Action for Public Transport (N.S.W.) Inc.

Submission on SSI 10038

Sydney Metro West EIS

Figure 3-2: Greater Parramatta Olympic Park station location options taken forward from initial investigations

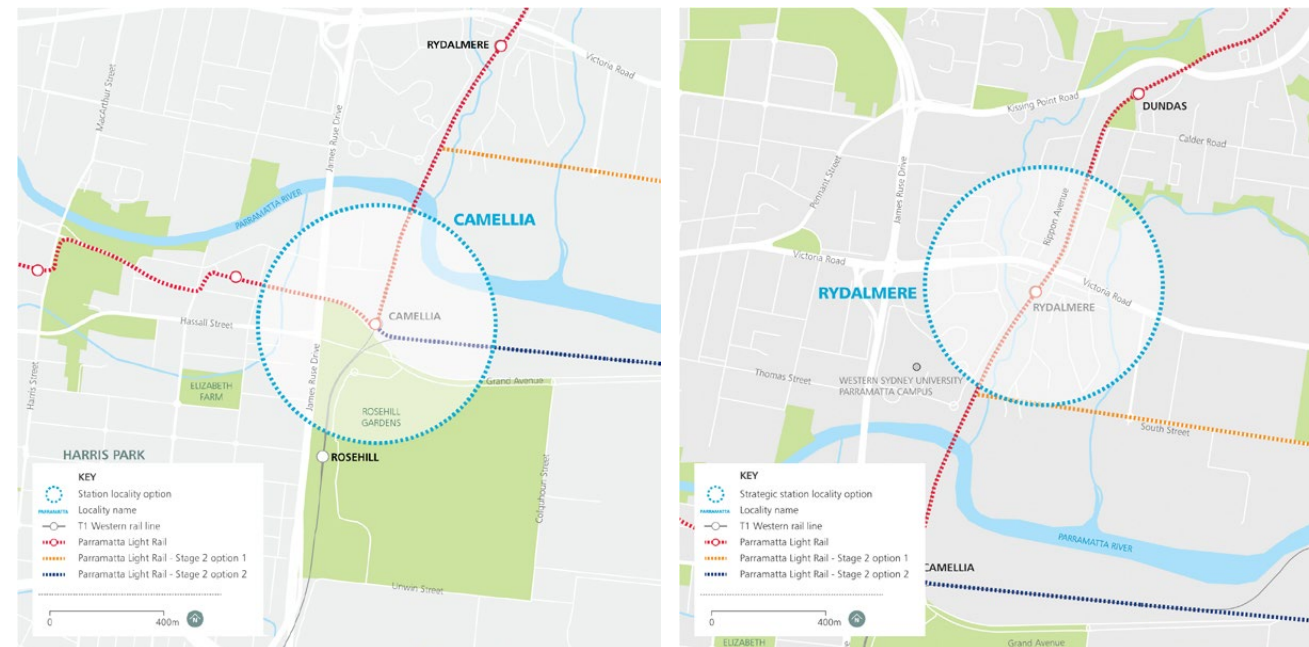
By contrast, the 7km gap between the proposed stations at Olympic Park and Parramatta is unusual and excessive in an urban context. APTNSW believes that there is a strong case for an additional stop at Pyrmont and possibly one at Camellia. The distance between Metro West and the light rail stop at Camellia is tantalisingly short:
